Response to Highway Consultee Note dated 02 June 2023

Project: Beaches Yard Horton Road Yiewsley

Subject: Planning Application 75221/APP/2022/2968

DATE	AUG 22	DRAWN	RD	CHECKED	DLW	EGGIE CHECKBOOK
DRAWING No.	6969.002	REV	J	SCALE	1:500	@ A1

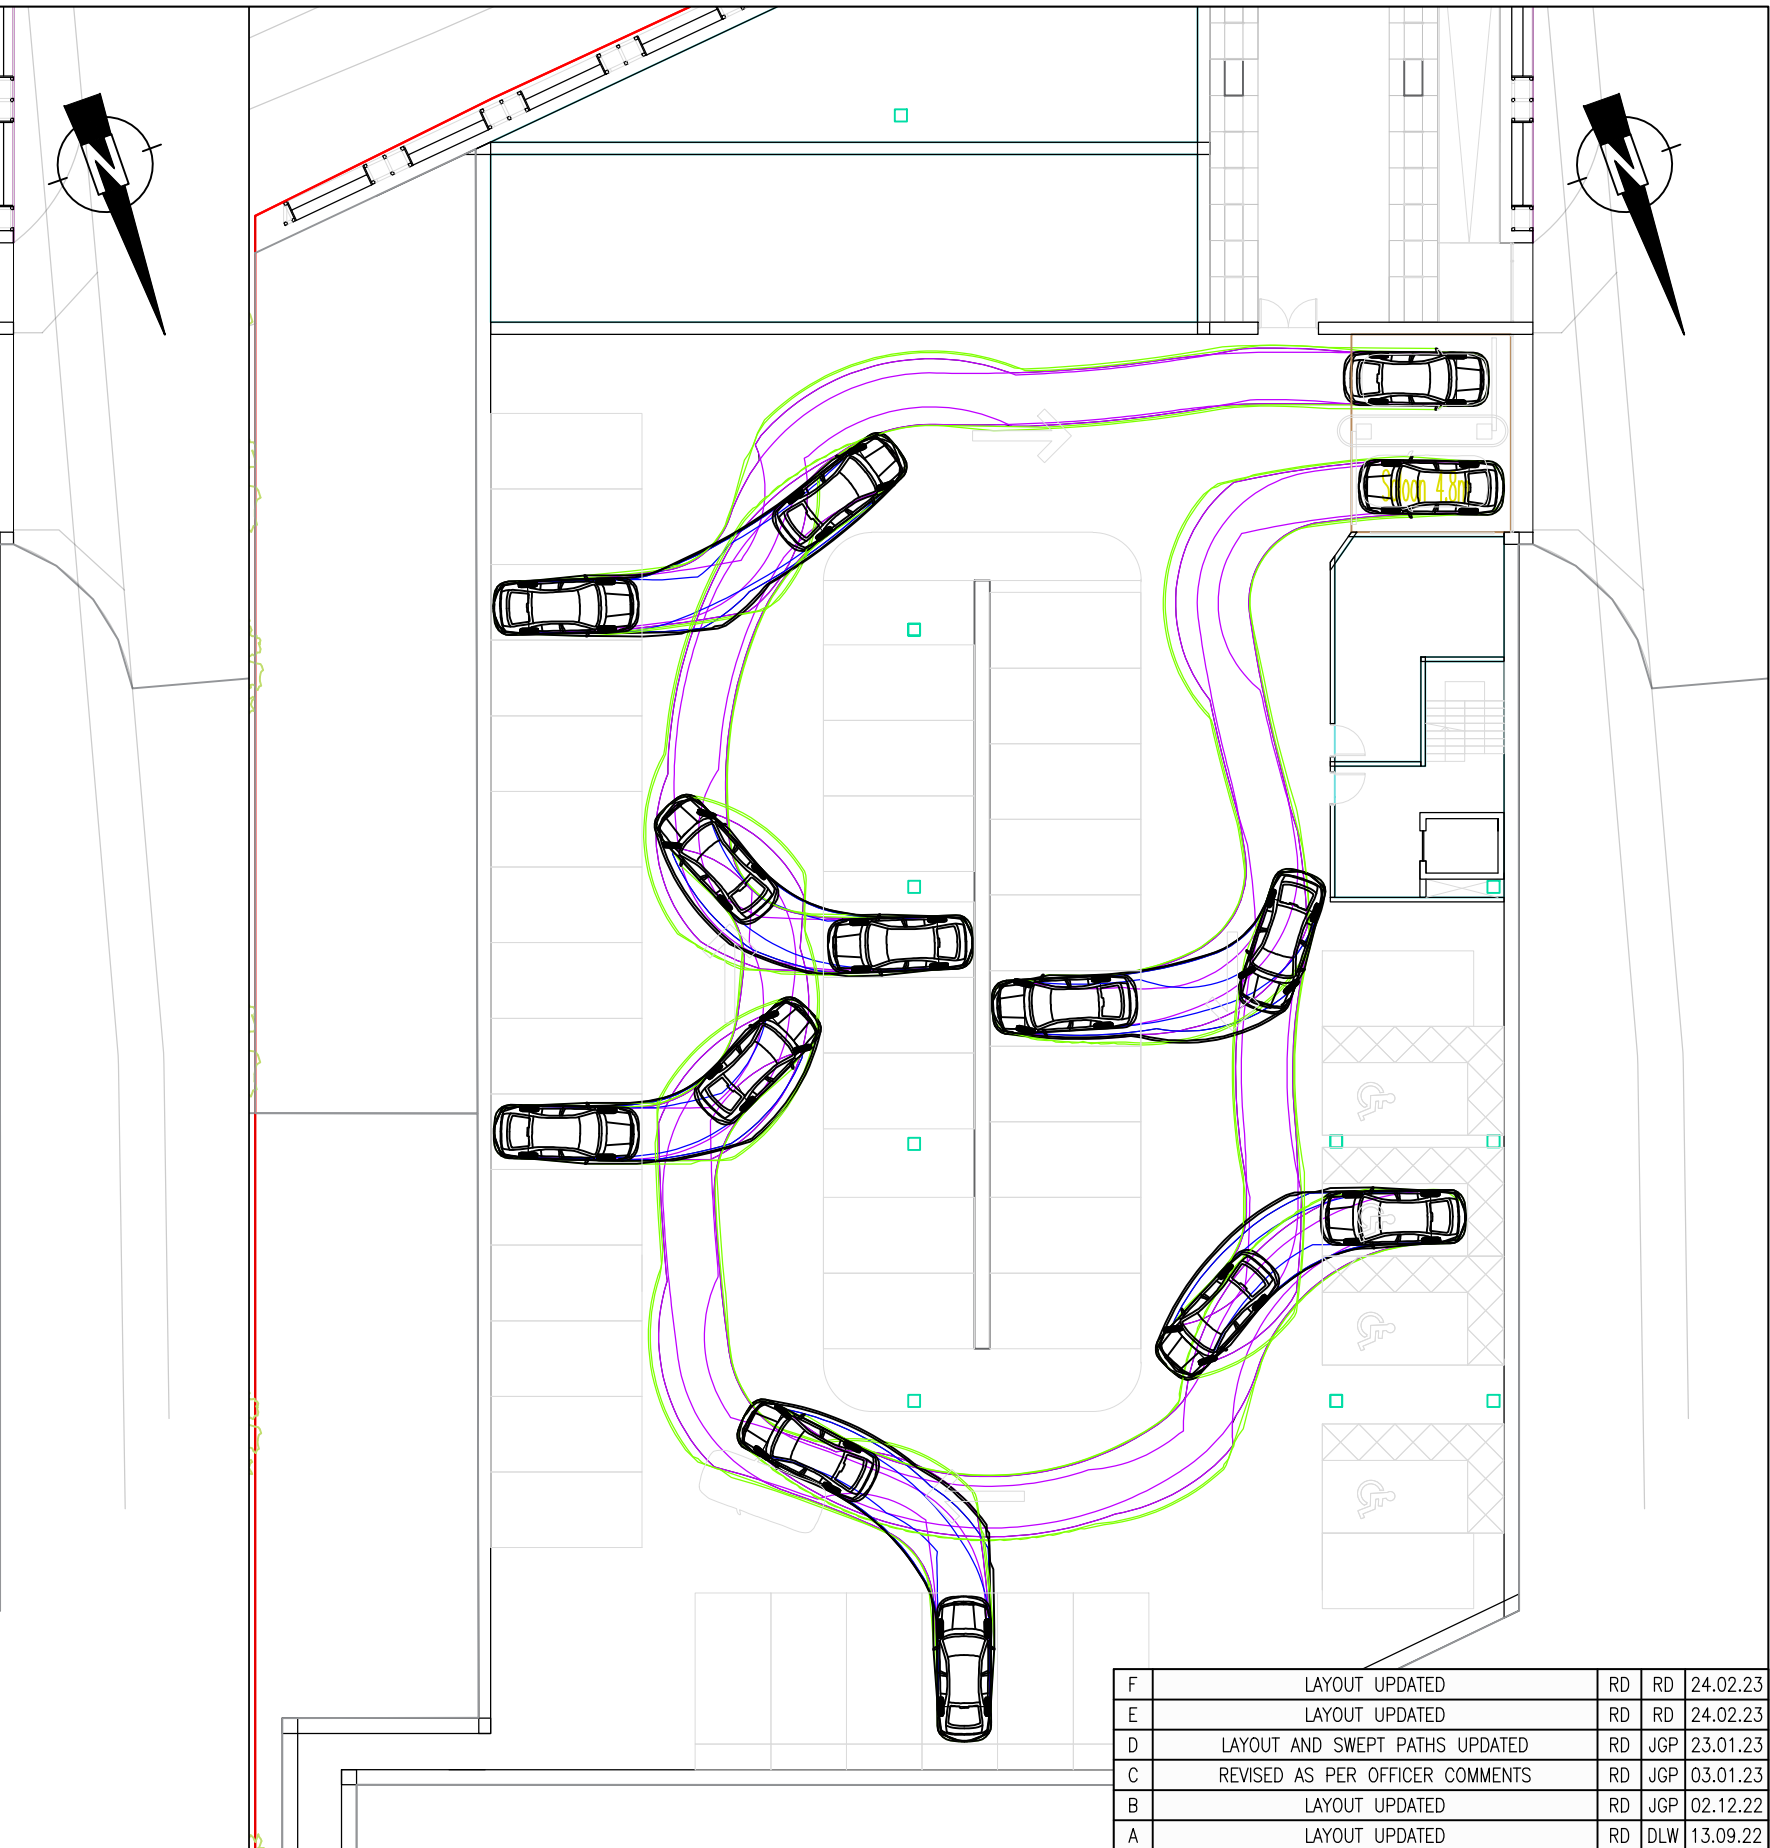
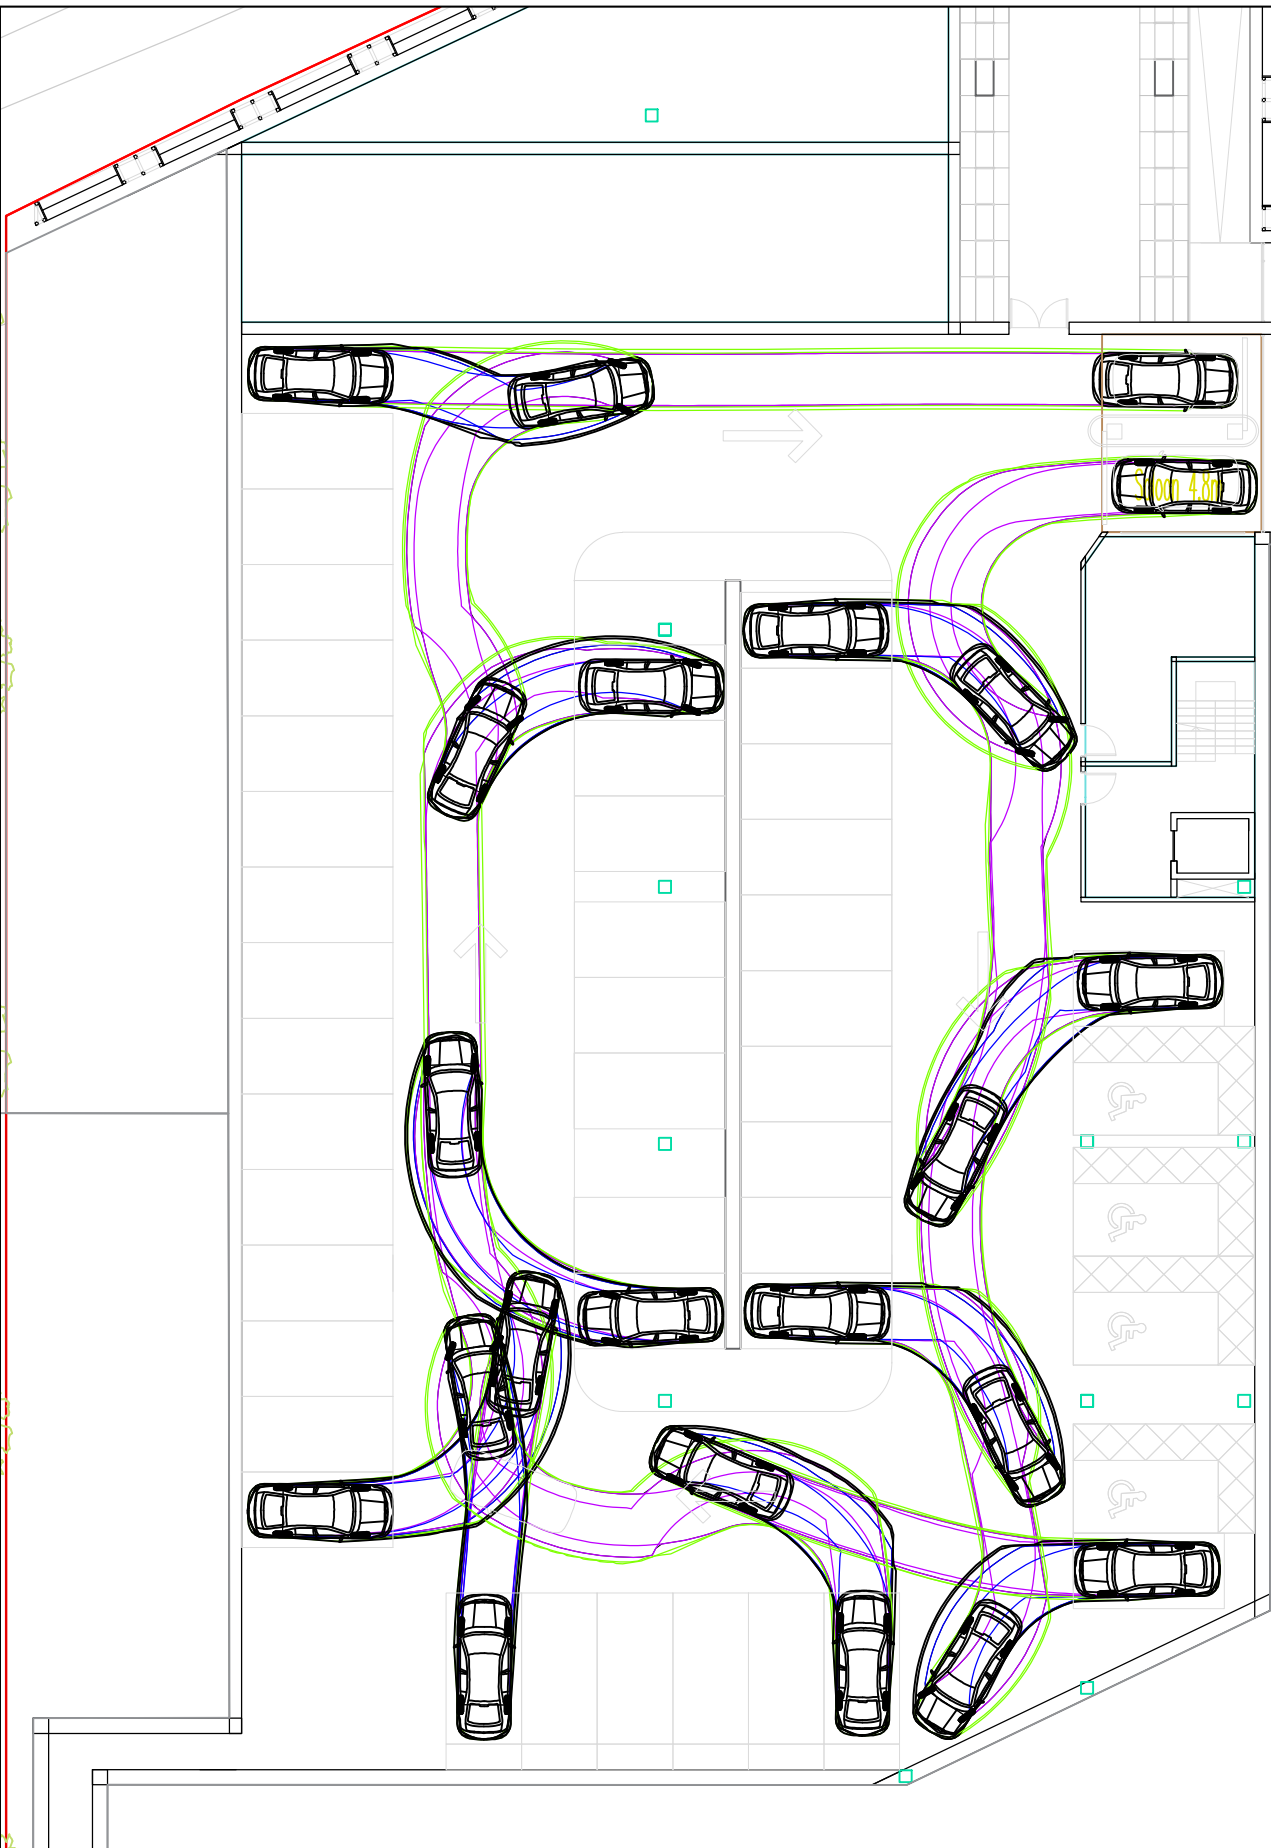
Highway comment: the Highway authority consider the geometry of both the site layout and access road to be unsuitable for use by 16.5m long HGV's despite the submitted vehicle tracking drawings demonstrating that there is sufficient width.

Highway comment: The officer states the above could be overcome by providing a 7m wide carriageway, parking bays of 2.5m width and 1.5m footway on either side of the carriageway.

SMA Response: it is normal practice to submit vehicle tracking drawings and if they work then the Highway Authority generally accepts this, built in this instance the highway officer hypothesises commenting on driver experience and cars parked

SMA Response: firstly there is no regulation requiring on street parking to be 2.5m wide, 2m width would suffice, there is already a footway provided on the northern side of the private road, this would be sufficient and to be asked to provide a footway on both sides is not necessary given the scale of the proposal. Again, I recommend Highways take a look at Horton Close where there is only one footway provided serving a significantly higher number of units than the single unit proposed here.

Despite MfS stating that 5.5m road is adequate for two HGV's to pass each other. SMA has prepared Drawing 6969.002J submitted with the TAA, shows widening of the private road to 8m. This width would allow parking on one side of the carriageway and provide sufficient width for two HGV's to pass one another. This improvement is significantly better than any of the adjoining industrial estate roads such as Horton Close and Stone Close.
